Recommendation Report for Planning Permission

REF NO: LU/324/14/PL

LOCATION: 13 Fitzalan Road
Littlehampton

PROPOSAL: Change of use of residential institution (C2 Residential Institutions) to form 3 No 2 bedroom flats (C3 Dwelling Houses) (resubmission following LU/207/14/PL)

PROPOSED Grd FLOOR PLAN

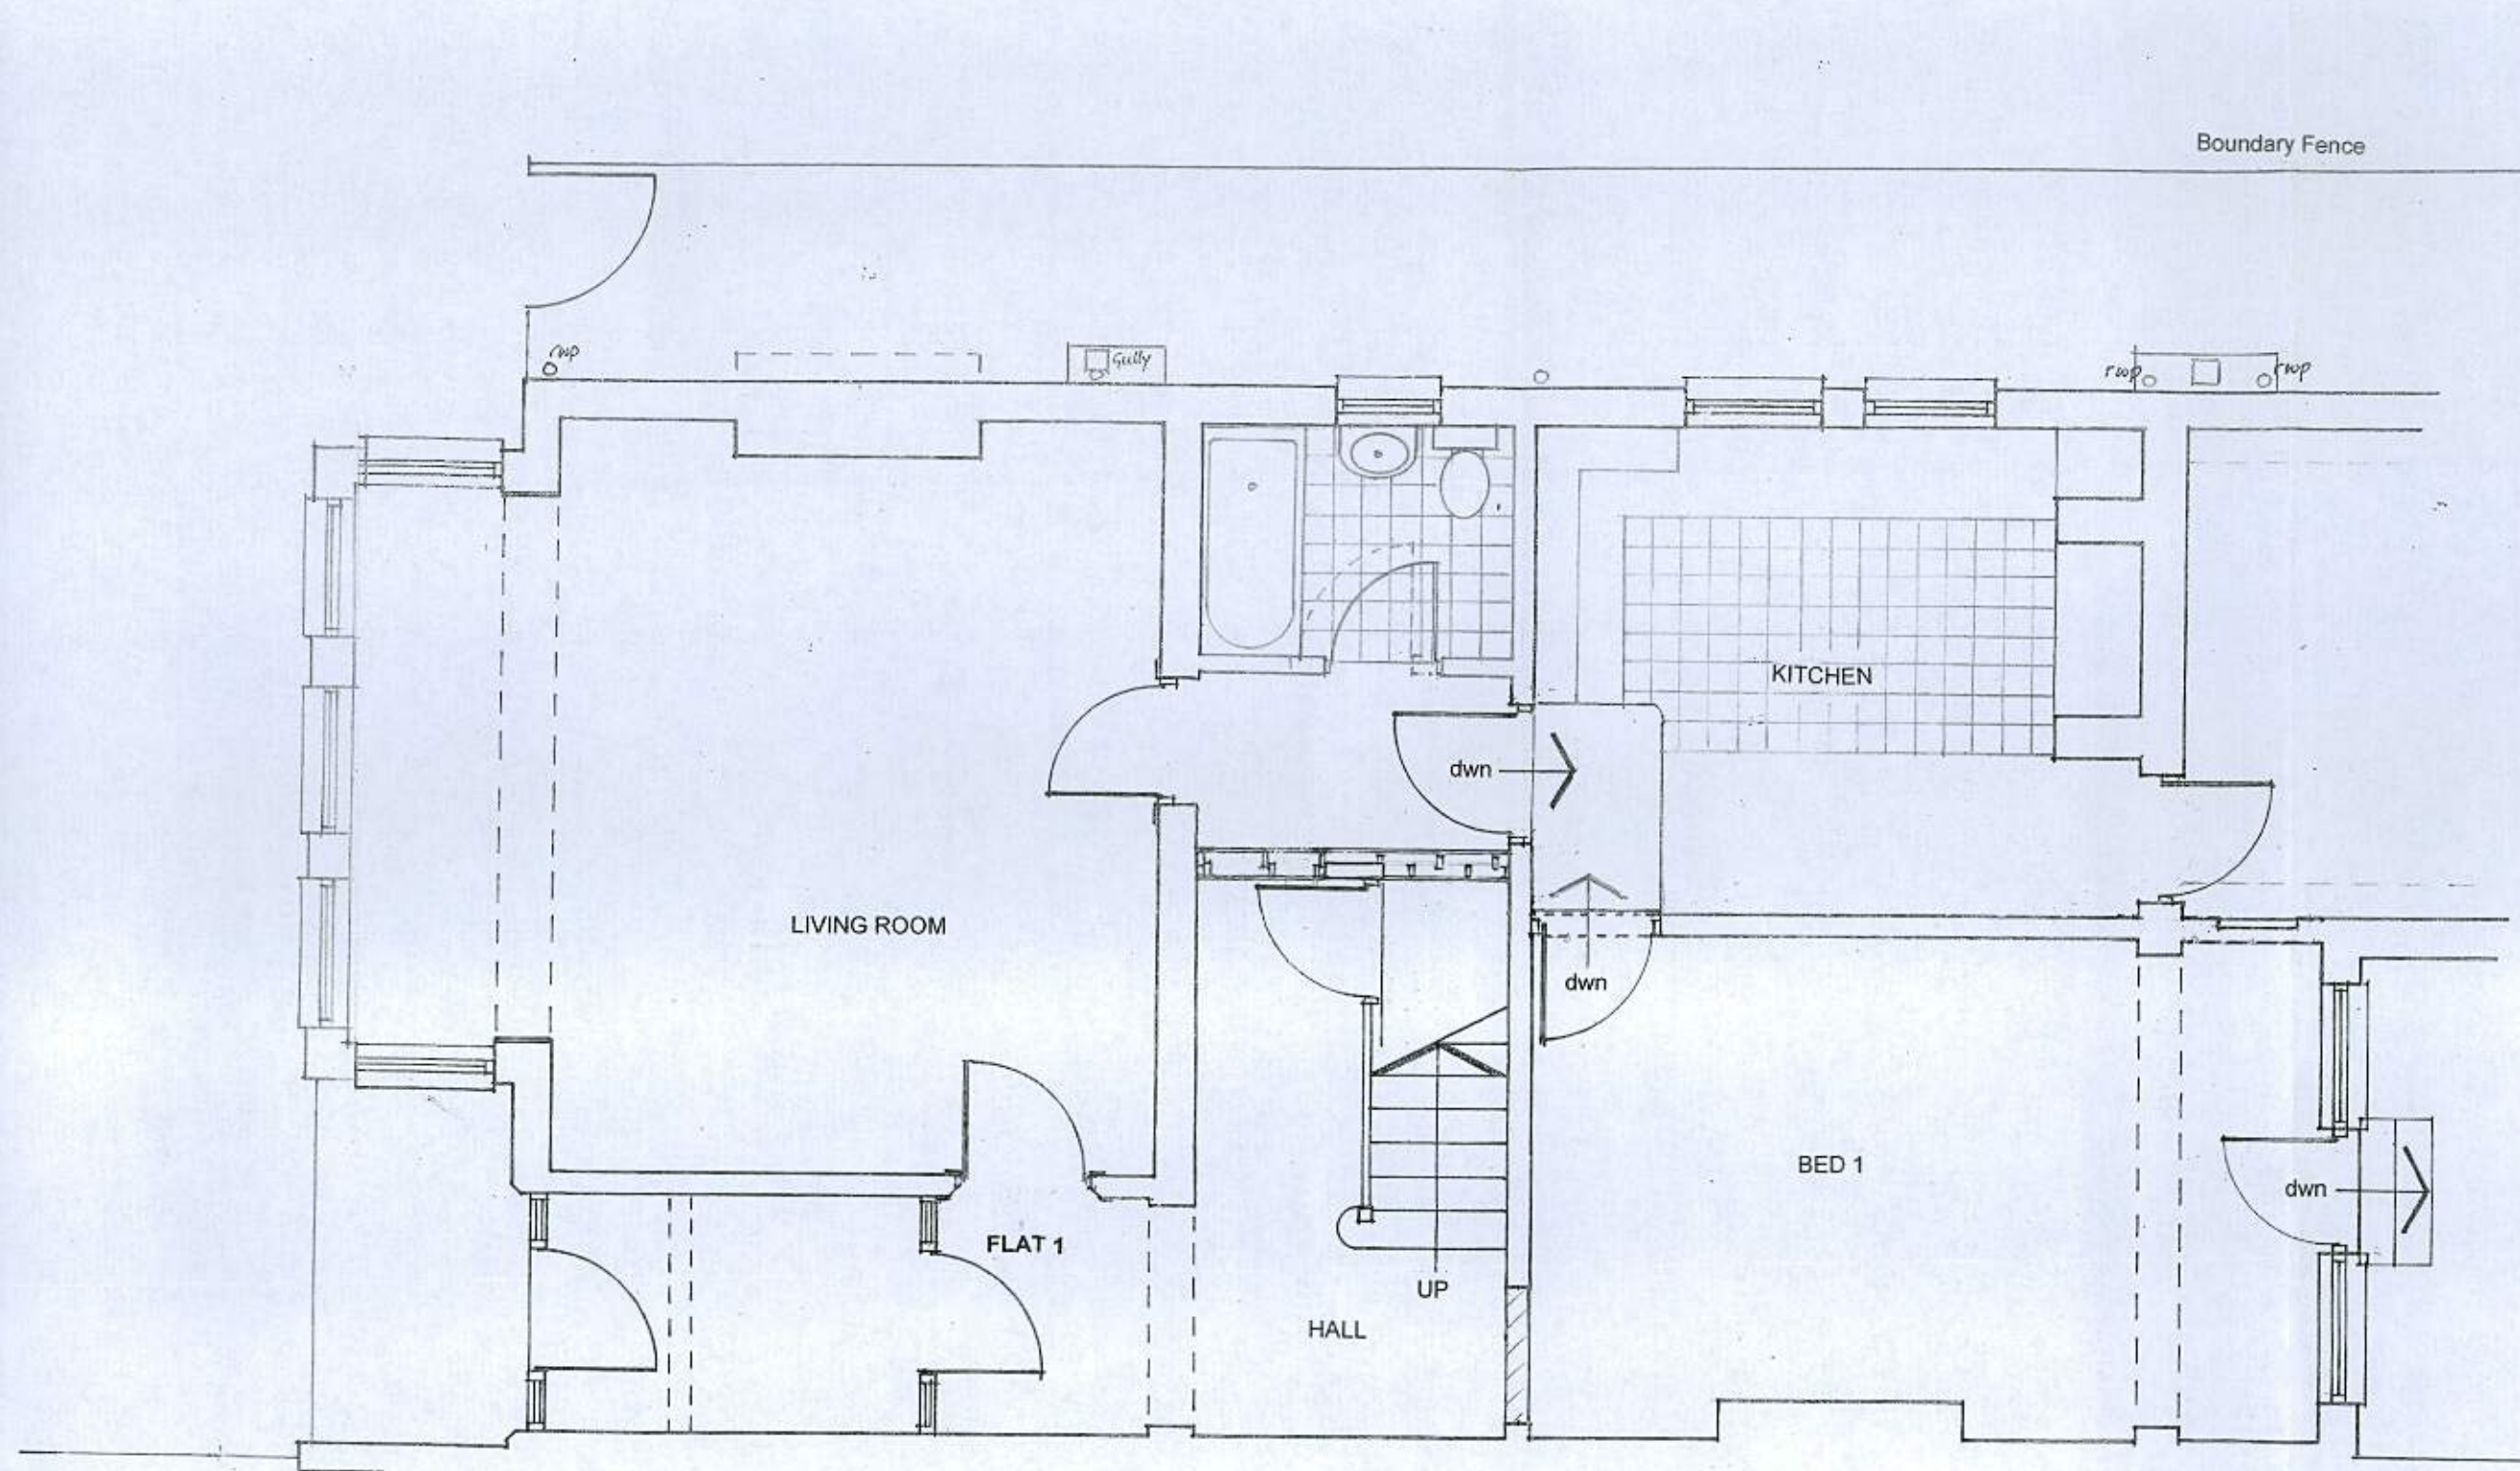
The proposal does not provide any car parking, but cycle parking is indicated. The site is sustainably located and County Highways have no objection.

- 3 The building shall not be occupied until the bicycle store shown on the submitted plans has been provided and constructed. The areas of land so provided shall not thereafter be used for any purpose other than the parking of cycles.

PROPOSED ELEVATION

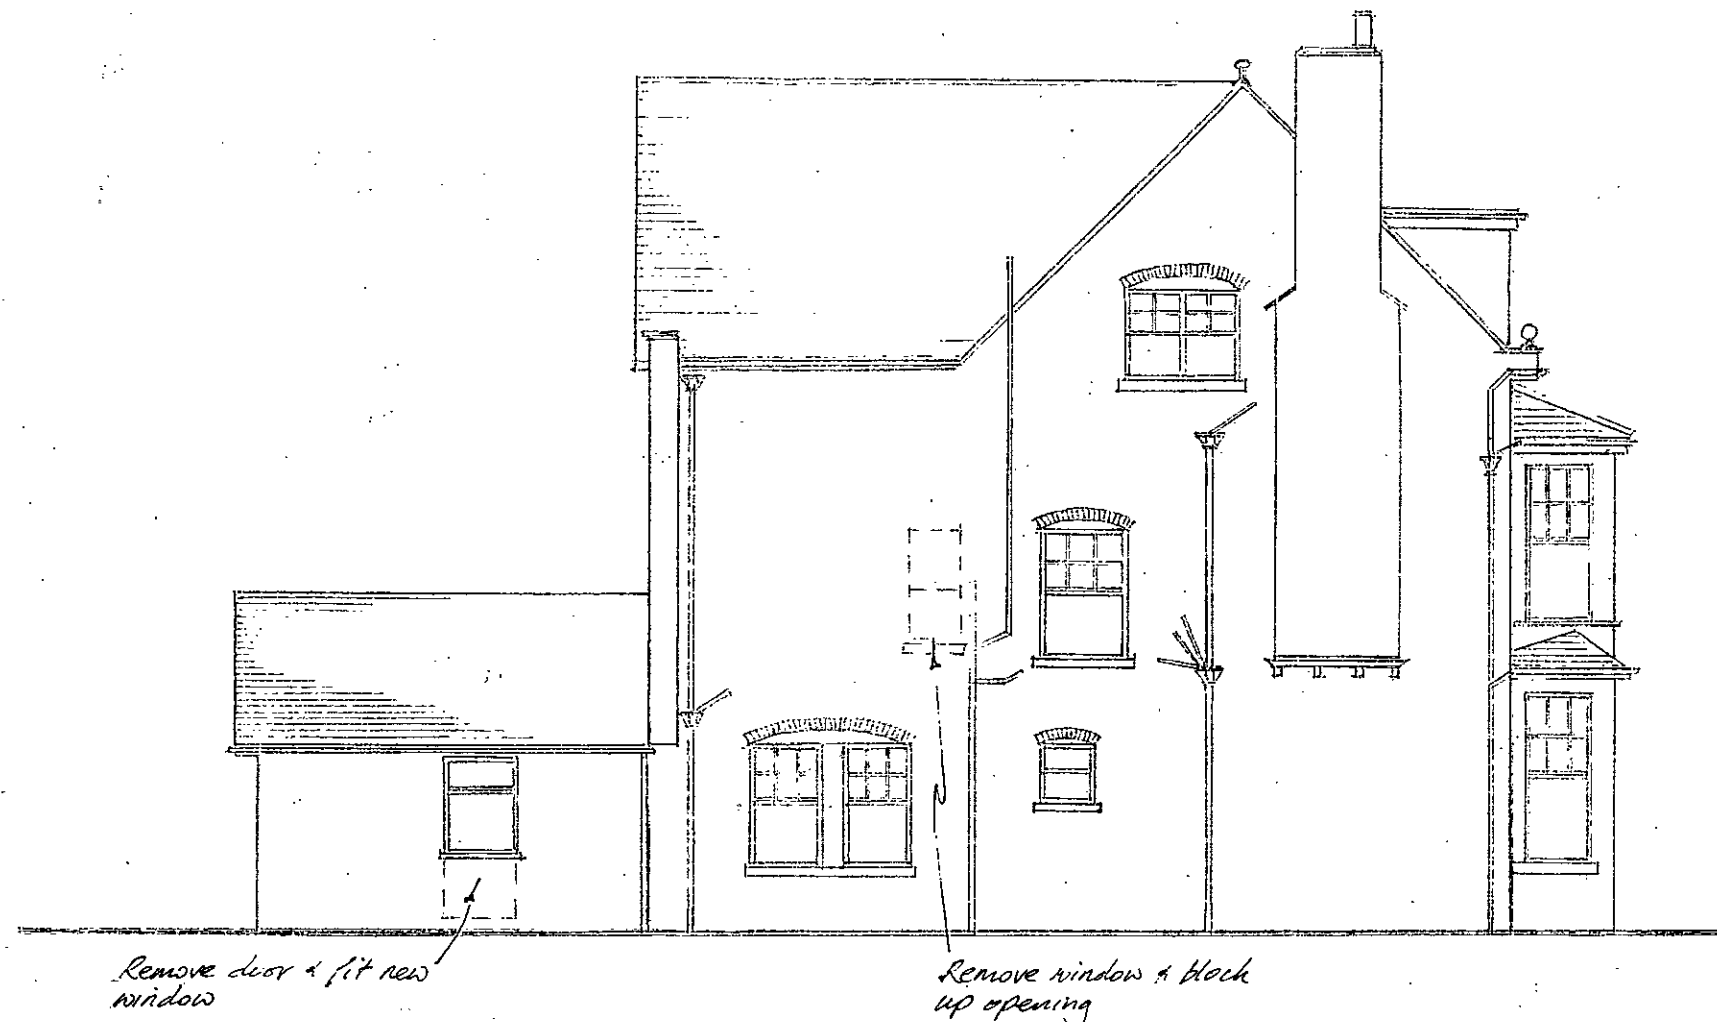
The development utilises the existing layout of the building and does not result in internal alterations which could damage the character of the building of special character. The only external change relate to the change from a window to a door and the blocking up of a small window on the south elevation which is acceptable.

- 4 The materials and finishes of the window and door infills hereby permitted shall match in colour and texture those of the existing building.
